October 29, 2025
Development Facilitative Team (DFT)
600 2nd St NW, Albuquerque, NM 87102

RE: Project: PR-2022-007565; SP2025-00075- SITE PLAN DFT Comment responses

To whom it may concern,
I am in receipt of comments provided on 10/22/2025 and have provided the following revisions, and responses to those comments:

LP-02

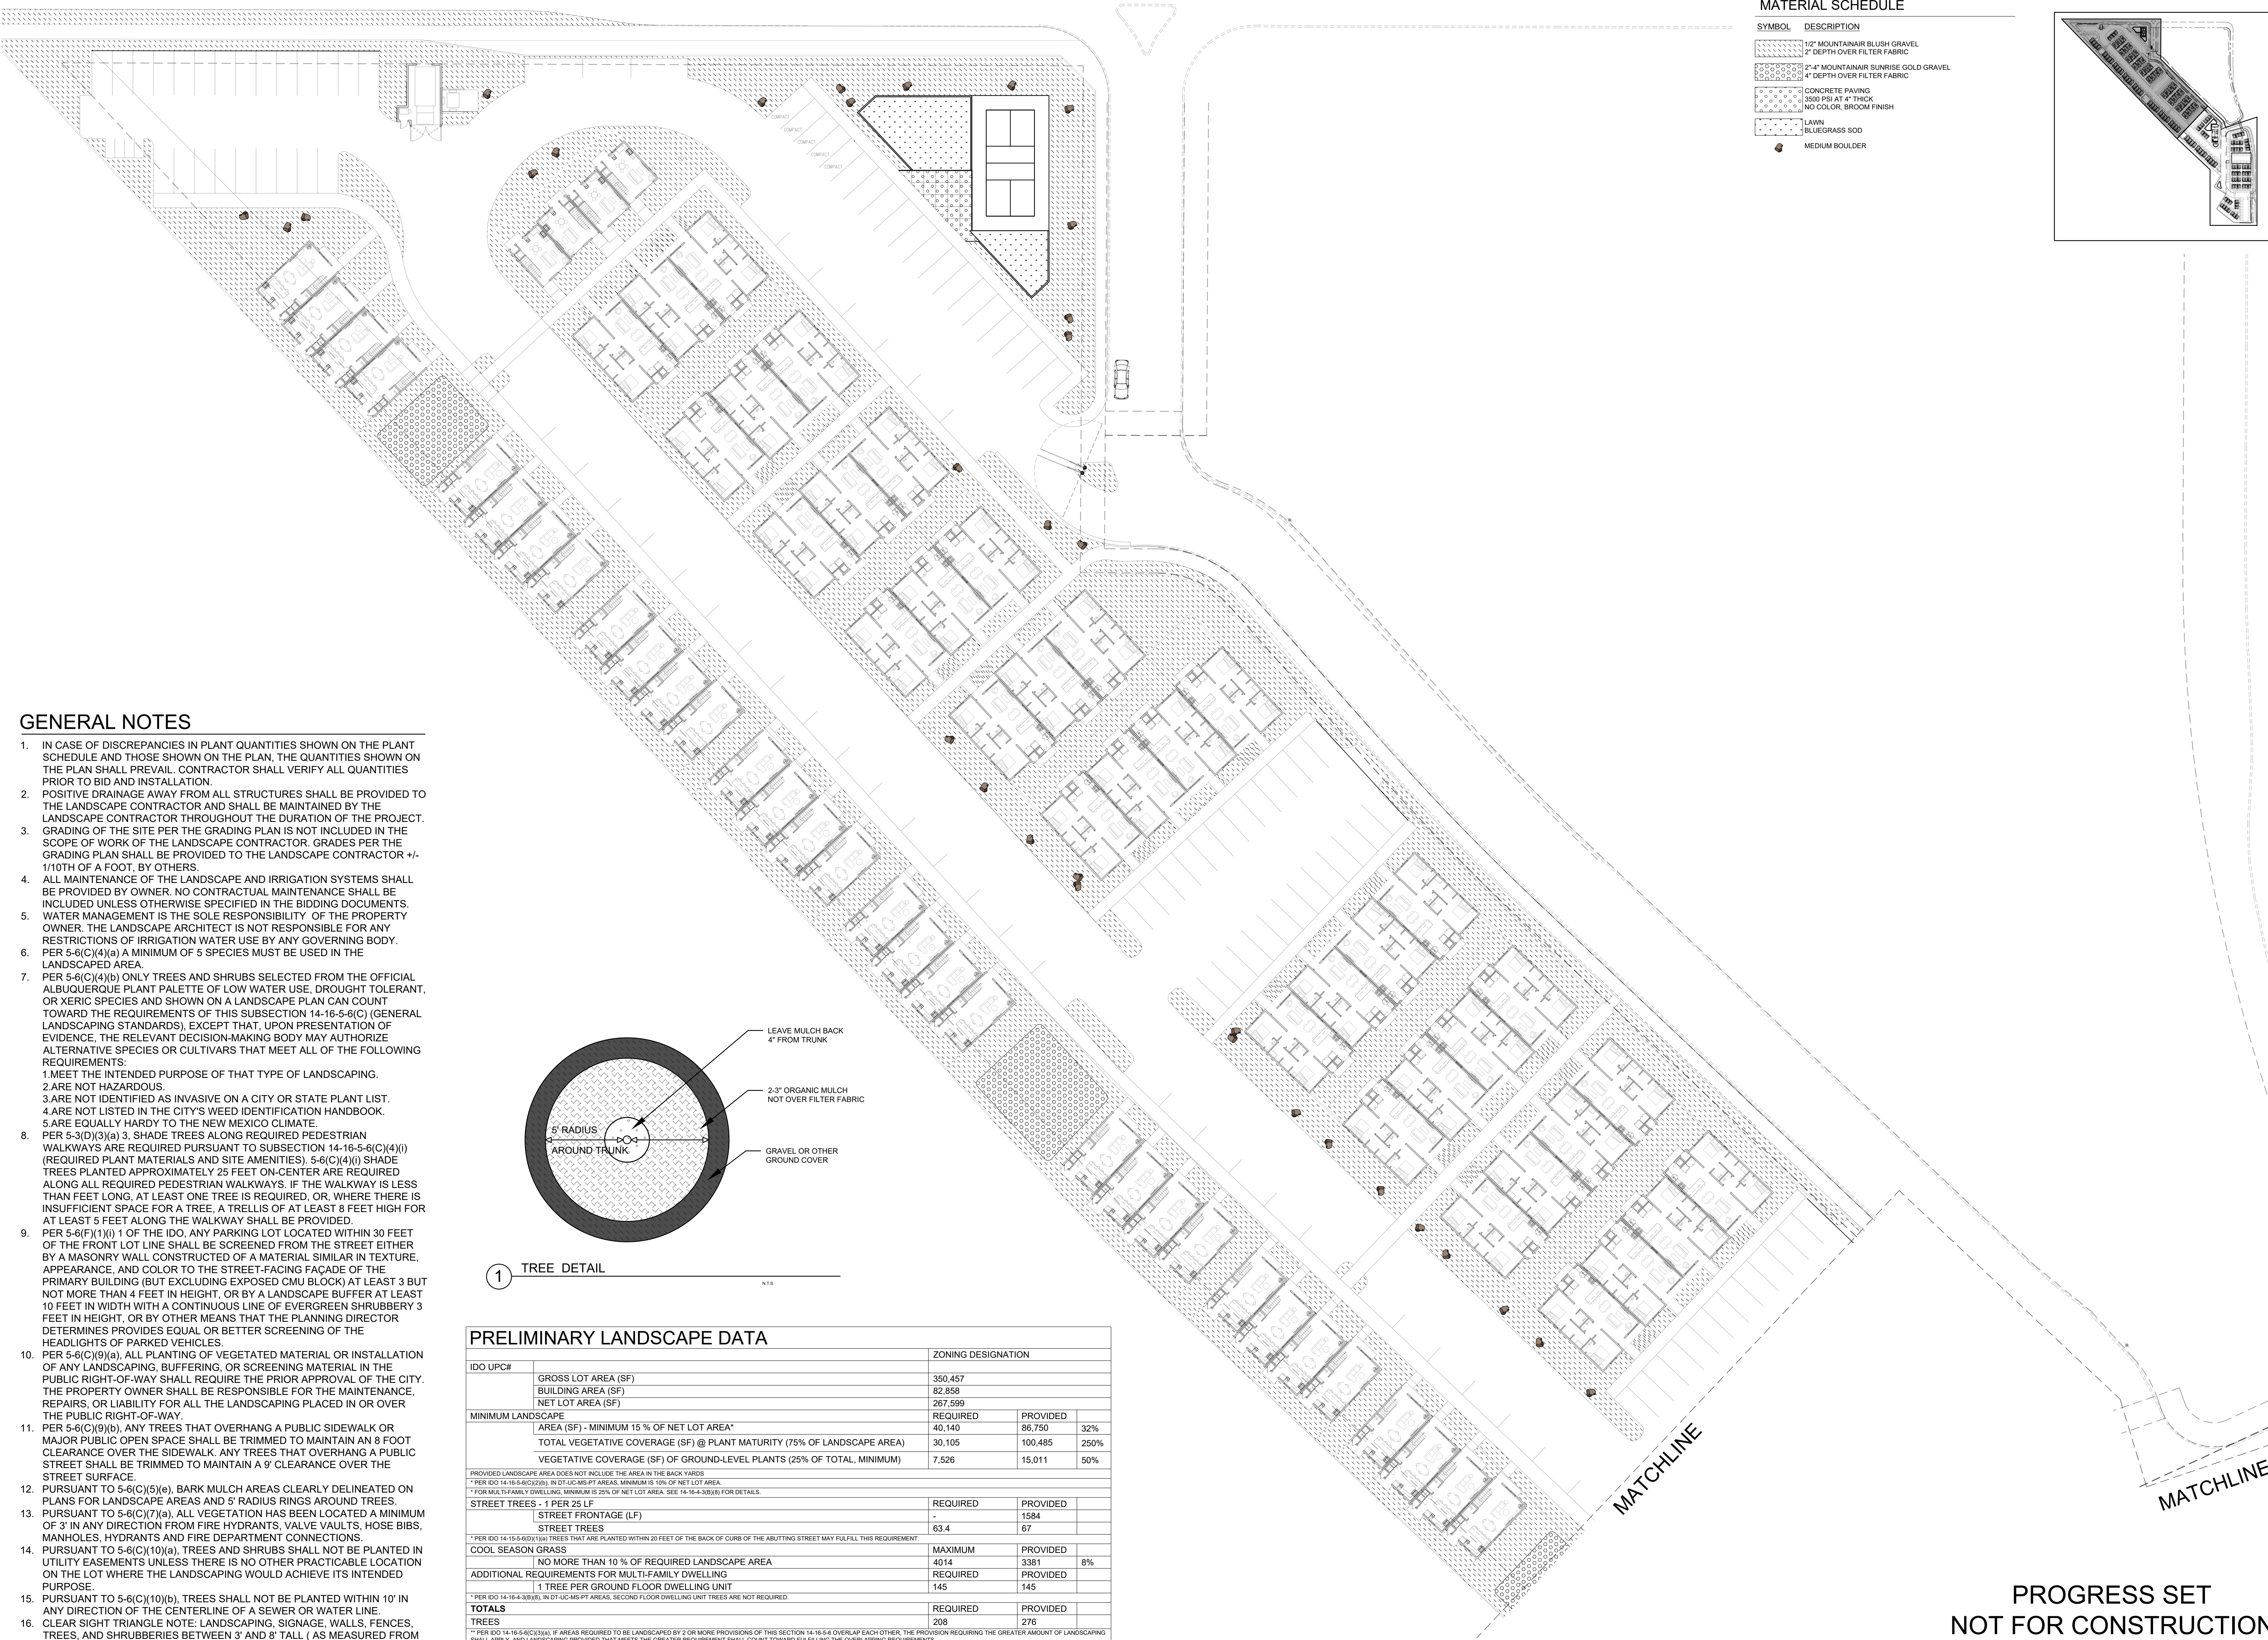
4. Serviceberries struggle with heat and high UV rays and are only recommended as an understory planting, per local nurseries. Serviceberry is also not on the Official Plant Palette. Please replace it with another species.

Response: Serviceberry has been removed from the project and replaced with plants from the official plant palette.

LS-01

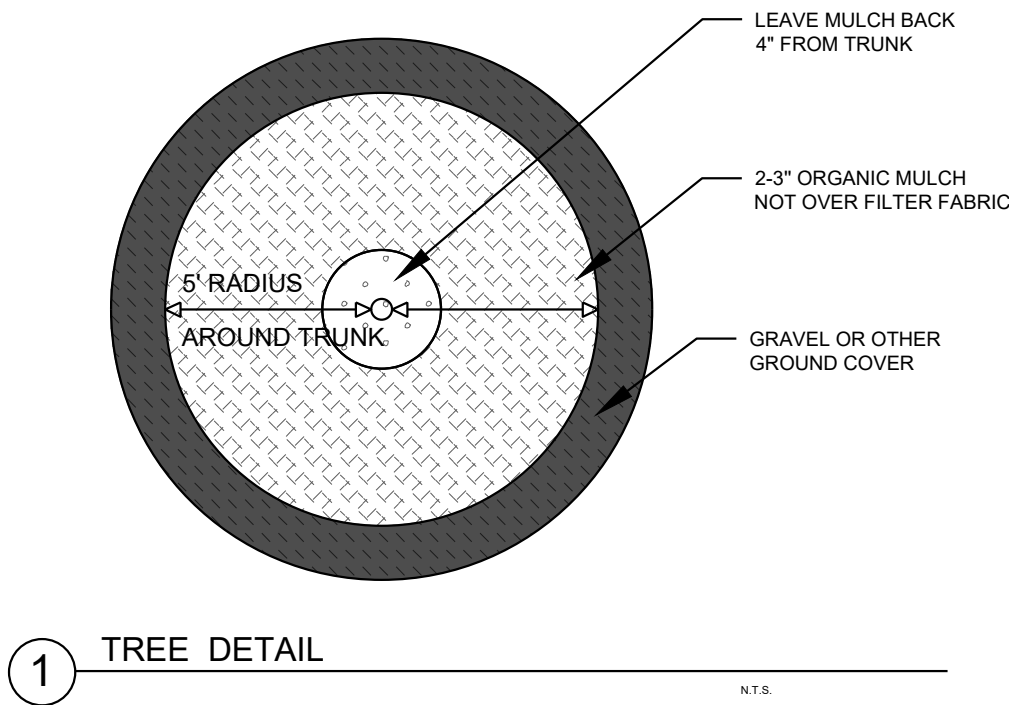
2. One (1) tree is required per 10 parking spaces. Calculations must be added to the landscape plan data.

5. Add the gravel coverage calculations for the 1/2" Blush Gravel and 2-4" Gold Gravel.

Response: This has been added to drawings

Response: This has been added to the drawings

MU-2

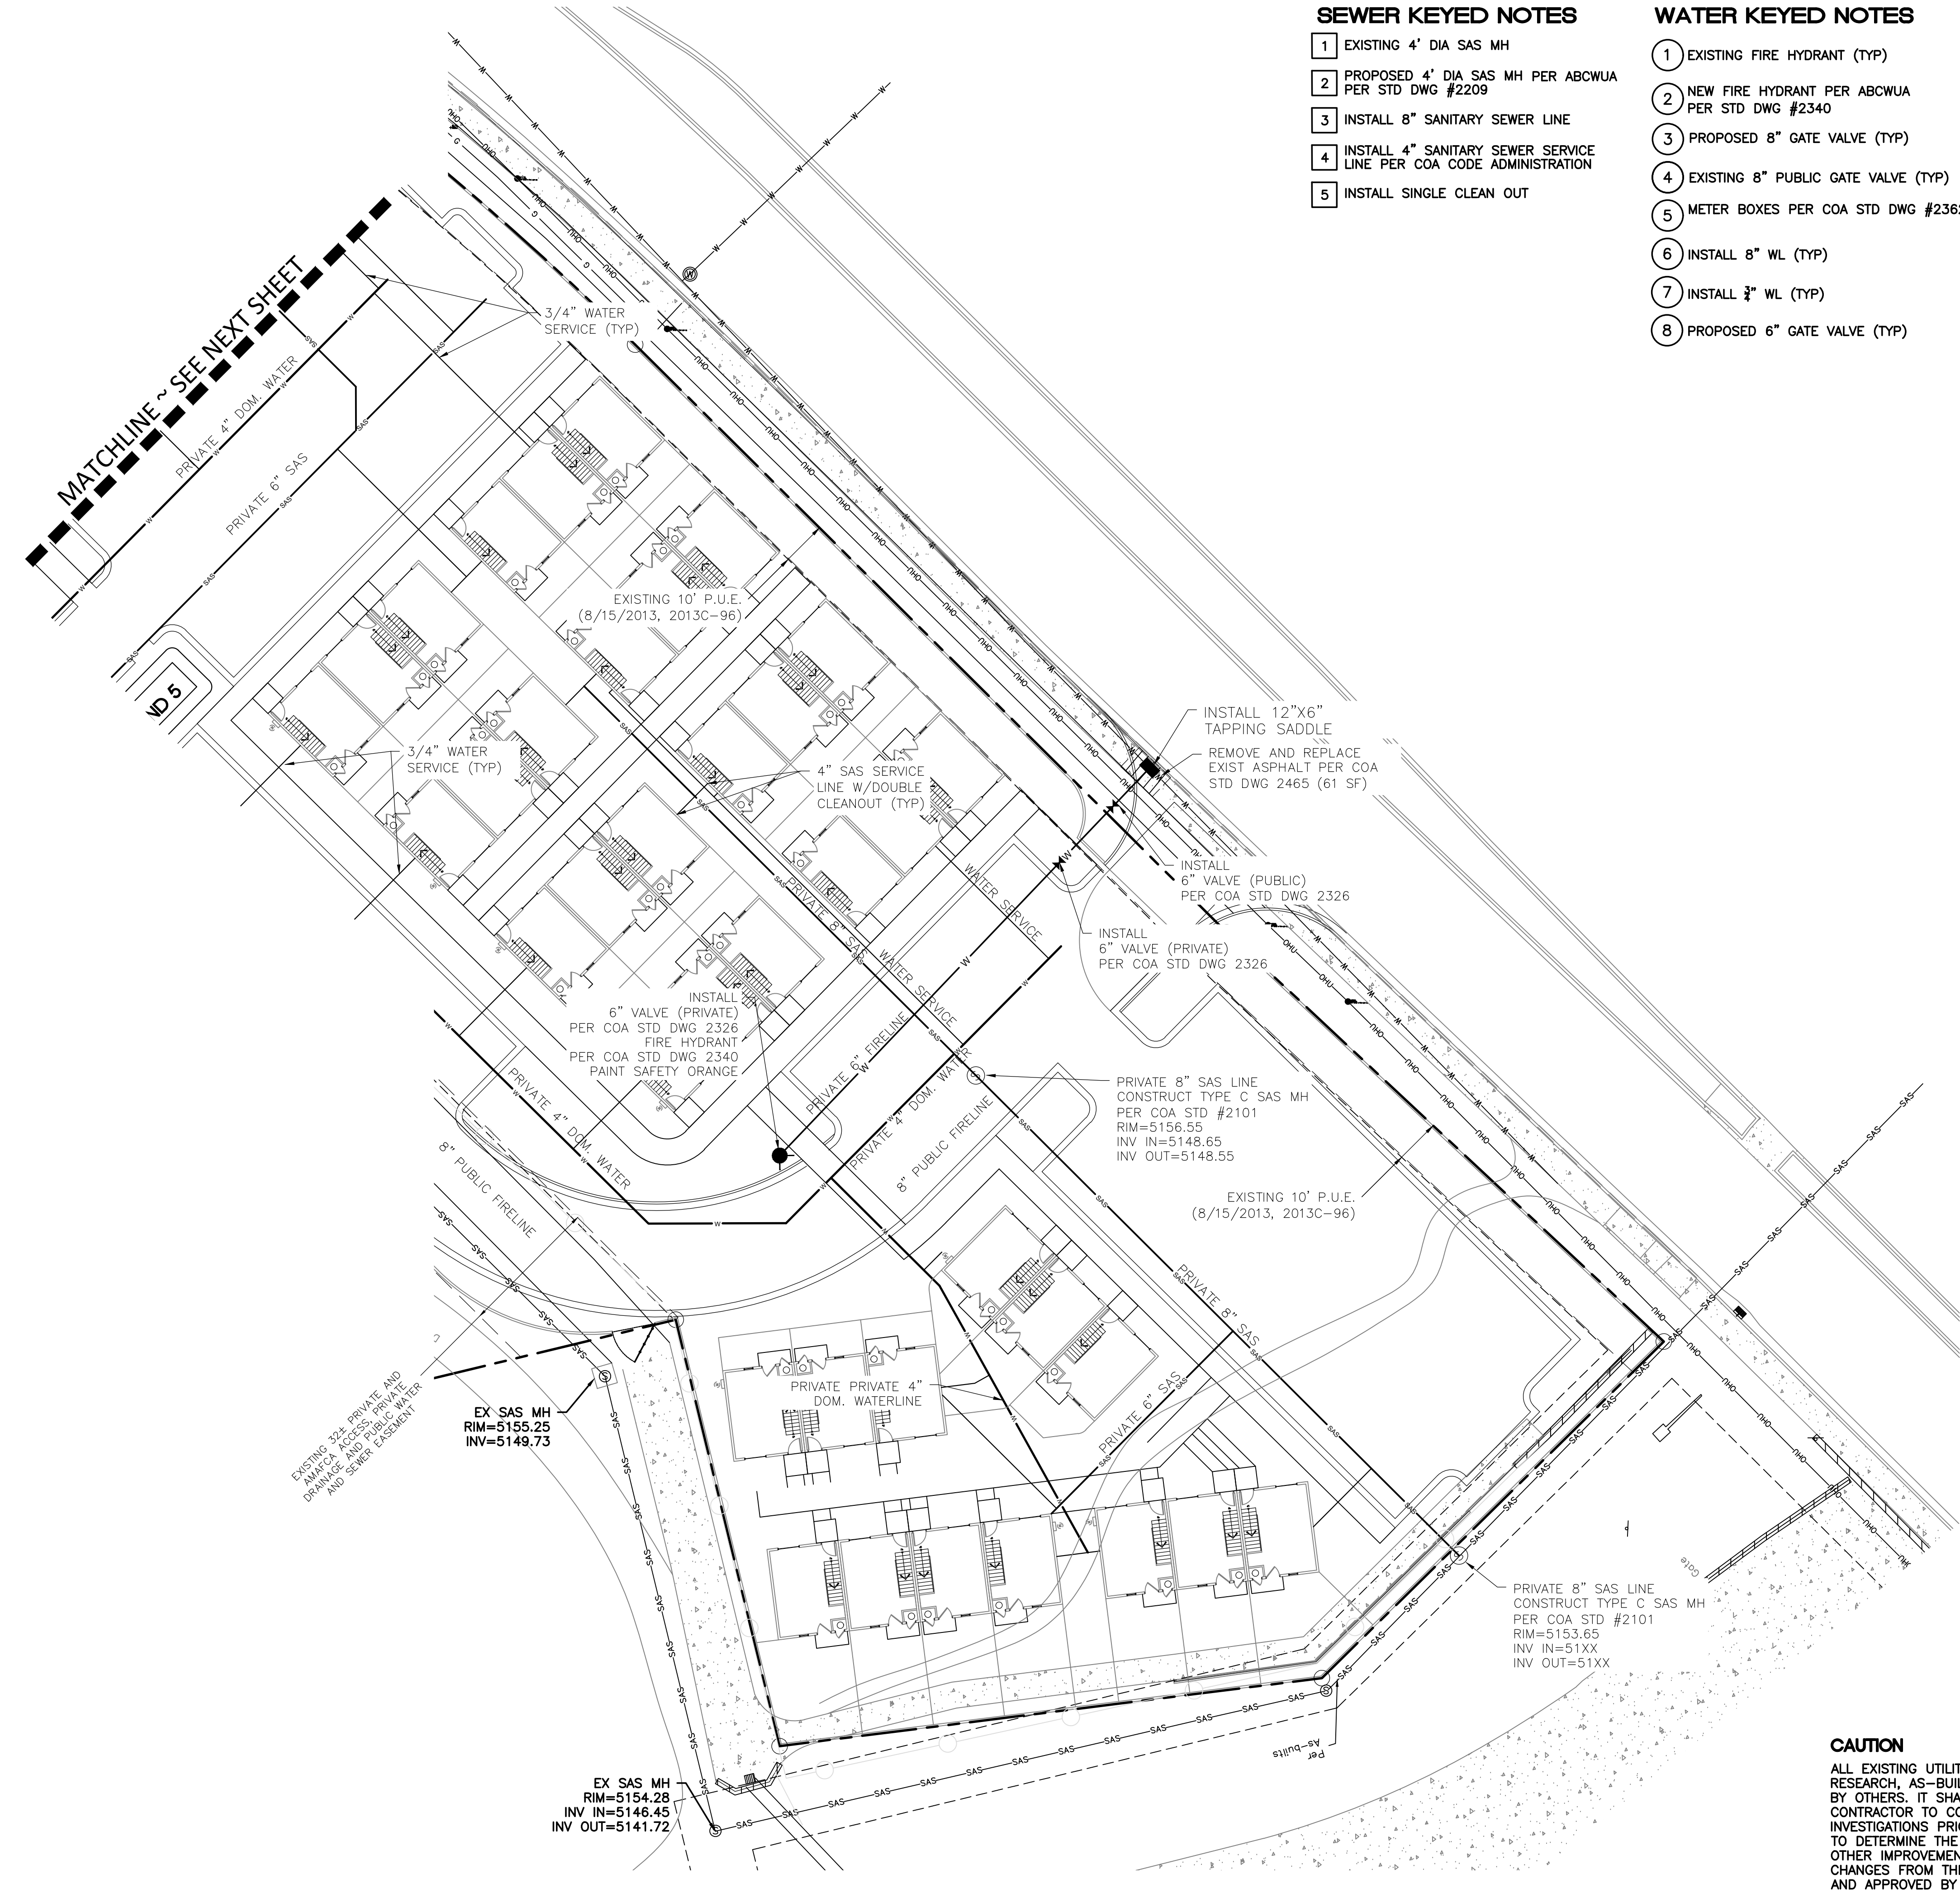
3. Need to show all utility easements as "public" or "private" and dimension each easement.

Response: All existing easements have been labeled on the master utility plan. No additional easements are being requested, public or private.
